**APPLICATION NO:** 21/00101/FUL/ADDINF

**DESCRIPTION:** Ground floor rear extension to kitchen and living space, and first floor shower room extension to bedroom 3.

**LOCATION:** 14 Grant Road Crowthorne Berkshire

Drawing  
**Proposed Ground and  
 First Floors**

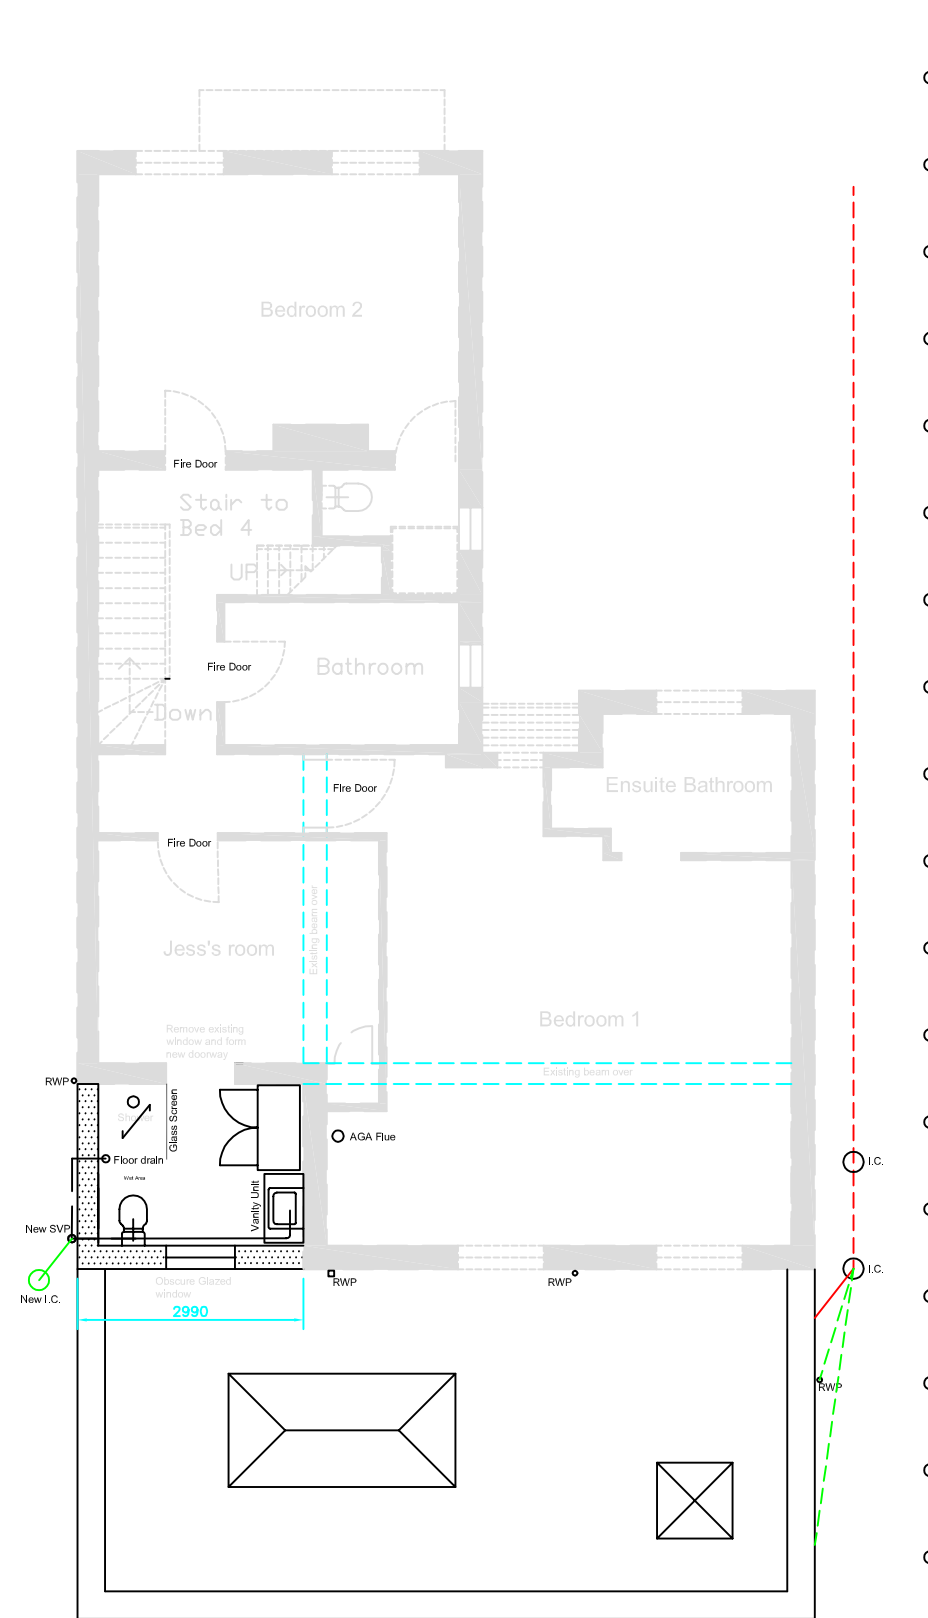
- 1 There appear to be some inconsistencies with the fenestration, i.e - there is a window on the existing and proposed South elevations that has not been shown on the floor plans, plus a window on the proposed North elevation not shown on the ground floor plan.
- 2 Please provide a block plan scaled at either 1:200 or 1:500 that shows the proposed development,
- 3 Could you please confirm whether both the rooflight and lantern on the single storey rear extension would be visible from the sides as only one has been shown.
- 4 The plans seem to show a partial garage conversion, if this is the case then please provide a parking plan.
- 5 Please confirm whether any part of the proposed development (including roof overhang) will be visible from the front elevation.
